Martins Creek Quarry Expansion – Application SSD 6612

I am opposed to the Martins Creek Quarry expansion.

This submission supplements my original submission in 2016 on the same application.

Figure 1-1: Location of traffic count sites referred to in this study

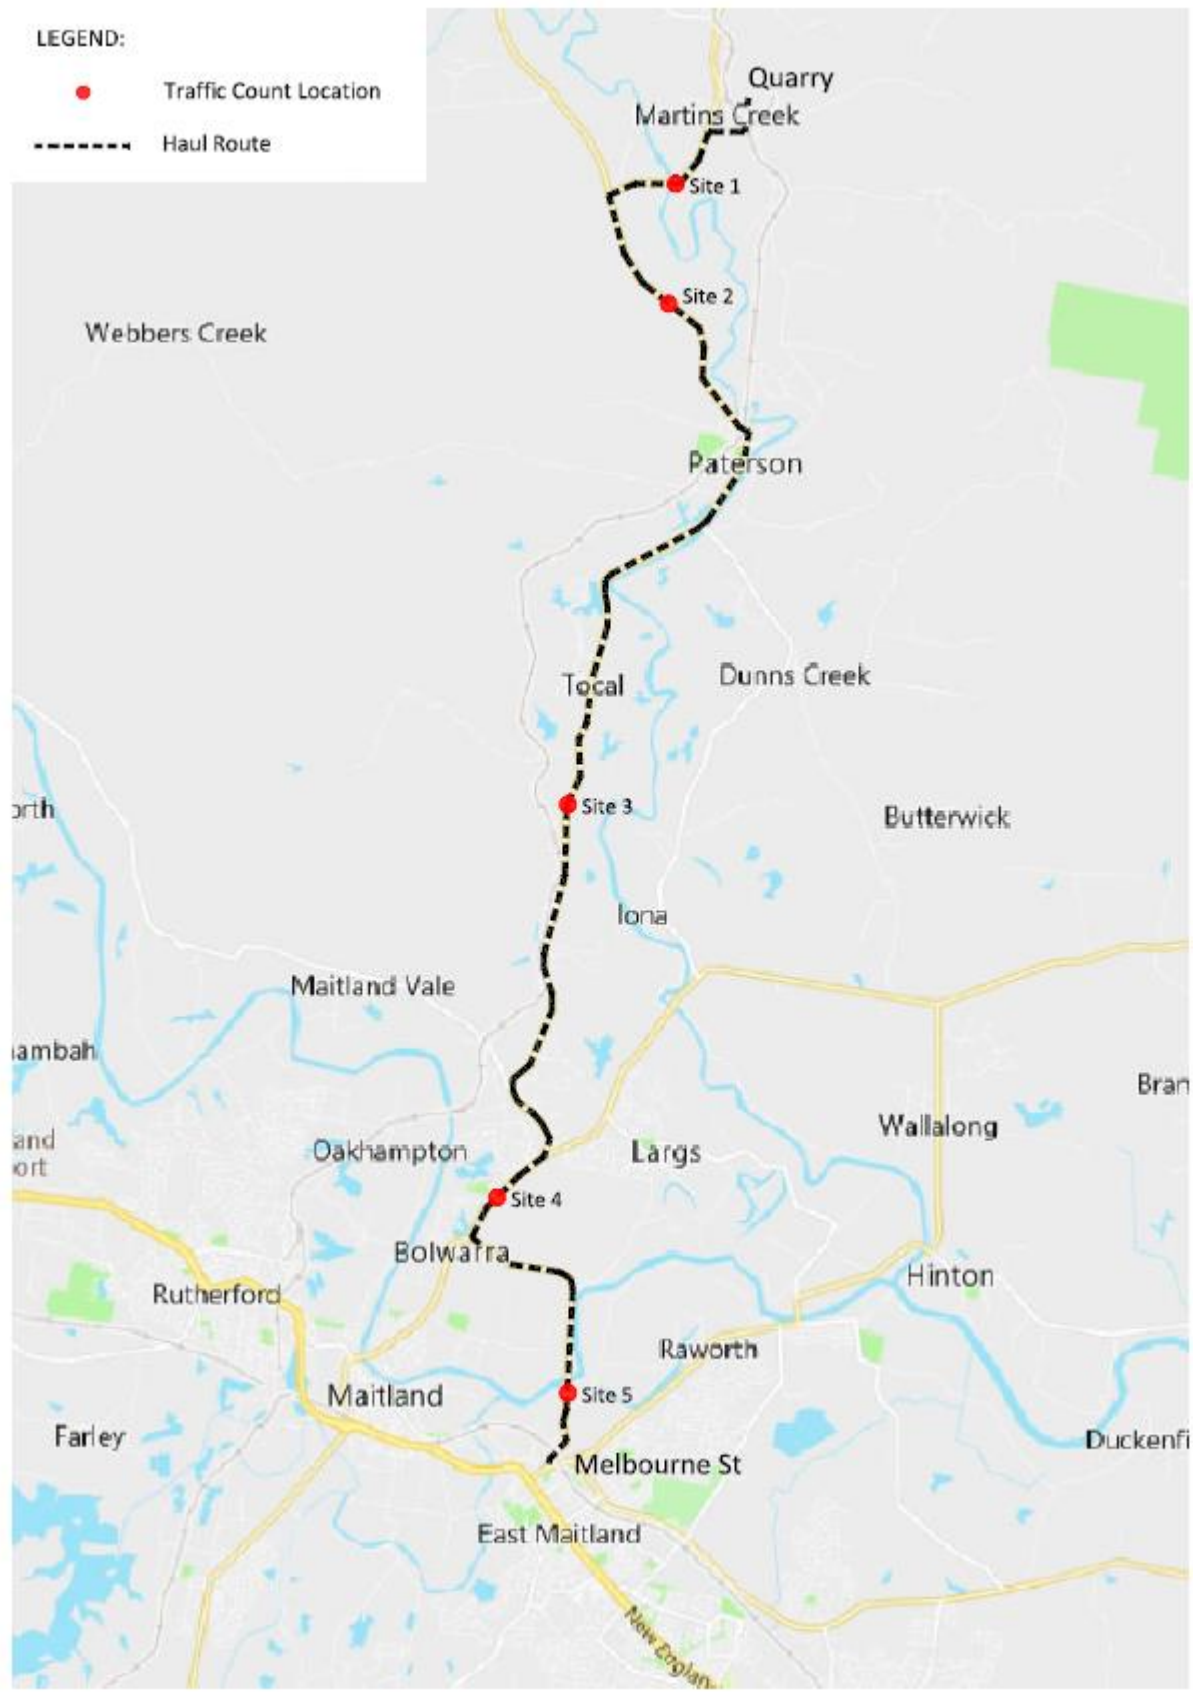
The SECA consultants have submitted a review of the haulage route which is littered with inconsistencies and has failed to address key aspects of the road network. The road network as analysed by SECA omits many key issues to avoid the scrutiny that is required for such a project.

The Traffic Survey conducted by SECA consultants has ignored the primary aspects of the haulage route and not addressed the key issues as outlined by Reed (2016).

- Narrow bridges that cannot accommodate passing vehicles especially large heavy vehicles at Gostwyck Bridge on Dungog Road
- A road that passes right through the township (as was the key design feature in those days). Past the shops, service stations, churches and community halls as well as residential areas. This is reflected by high pedestrian activity from residents and visitors. A small but busy shopping precinct. (Refer Figure 8)
